SEA ESTATE RUSTINGTON - PROPOSED TPO WORK – 2017-2018 (issue 2) revised Jan 2017

Crown lift: comments struck through indicate original proposal – R/252/17/T

Revised comments are those advised by Arboriculturist dated 5 December 2017

SEA ESTATE RUSTINGTON
 PROPOSED WORK TO TREES WITH PRESERVATION ORDERS (TPO'S)
 2017 - 2018
 REFER TO TABLE FOR SCOPE OF WORK

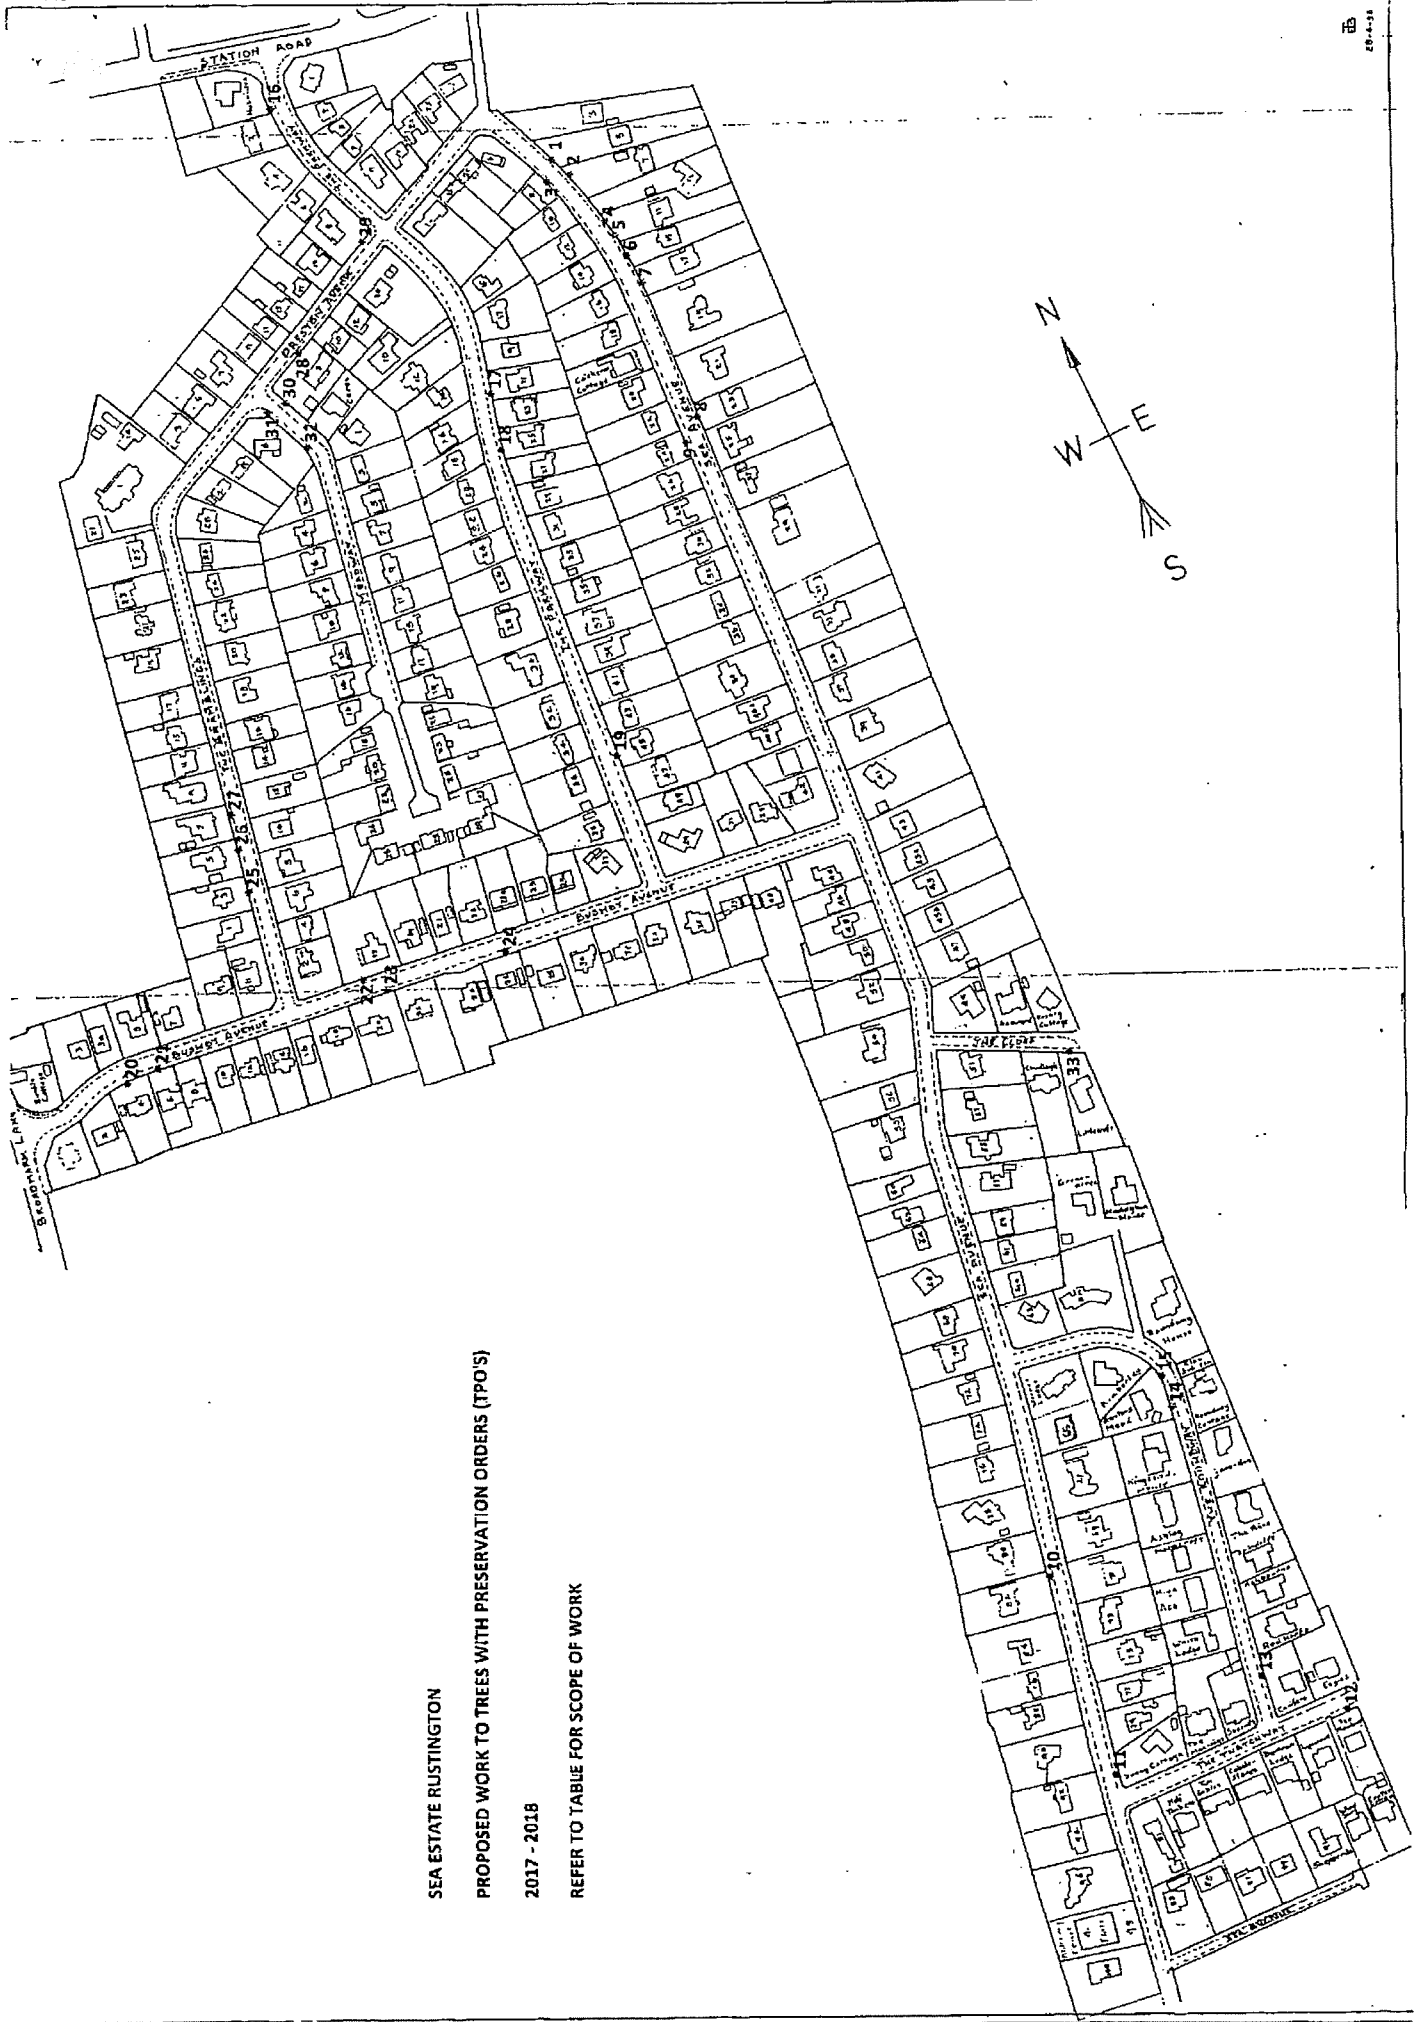
No	HOUSE NUMBER OR NAME	ROAD NAME	TREE TYPE	TYPE OF WORK	COMMENTS/PROPOSED WORK
8	23	Sea Avenue	Corsican Pine	CL	<i>Crown Lift removing all branches 10cm diameter or smaller to a height of 3-5m</i> Crown lift by removing only the two lowest whorls of branches
9	24	Sea Avenue	Corsican Pine	CL	<i>Crown Lift to 3-5m by removing 6 lower branches to clear driveway and maintain balance of tree</i> Crown lift by removing only the two lowest whorls of branches
12	Sea Meadows	The Thatchway	<i>Ash</i> Ailanthus/ Tree of Heaven	CL	Remove two major limbs on east side to clear footpath and driveway to a height of 3m
20	4	Bushby Avenue	Cherry	FELL	Fell and grid out extensive root system. <i>Consider replanting in two years' time at same location.</i> Replant immediately in same location Leaving site for two years is based on advice from tree surgeon; risk of honey fungus infection. Will revert to tree surgeon for further advice.

21	6	Bushby Avenue	Acer	CL	<i>Crown lift to 3m all round 5m on roadside; branches less than 3cm diameter</i> Crown lift to 4m over road and 2m in all other directions
25	3	The Bramblings	Corsican Pine	M/S	<i>Reduce three lowest west facing branches by 1.5m back to live branches</i> Reduce the three lowest branches facing west by a maximum of 1m
26	5	The Bramblings	Corsican Pine	M/S	<i>Reduce lowest west facing branch by 1.5m</i> Reduce the lowest west facing branch by a maximum of 1m
27	7	The Bramblings	Corsican Pine	M/S	<i>Reduce five lowest west facing branches by 1.5m</i> Reduce the five lowest west facing branches by a maximum of 1m
28	8	Preston Avenue	Cherry	CL	<i>Crown lift roadside and remove epicormic growth</i> Crown lift to 4m roadside on branches up to 5cm and remove epicormic growth
29	Op 14	Preston Avenue	Birch	CL	<i>Crown lift to 5m limbs less than 5cm</i> Crown lift to 5m removing only branches up to 4cm in diameter

30	Entrance E	Meadway	Acer	CL	<i>Crown Lift 4m roadside branches less than 5cm</i> Crown lift to 3m on roadside only by removing branches less than 5cm in diameter
31	Entrance W	Meadway	Pillar Beech	CL	<i>Crown Lift to 3m on all sides branches less than 4cm</i> Crown lift on all sides by 2m only removing branches up to 4cm in diameter
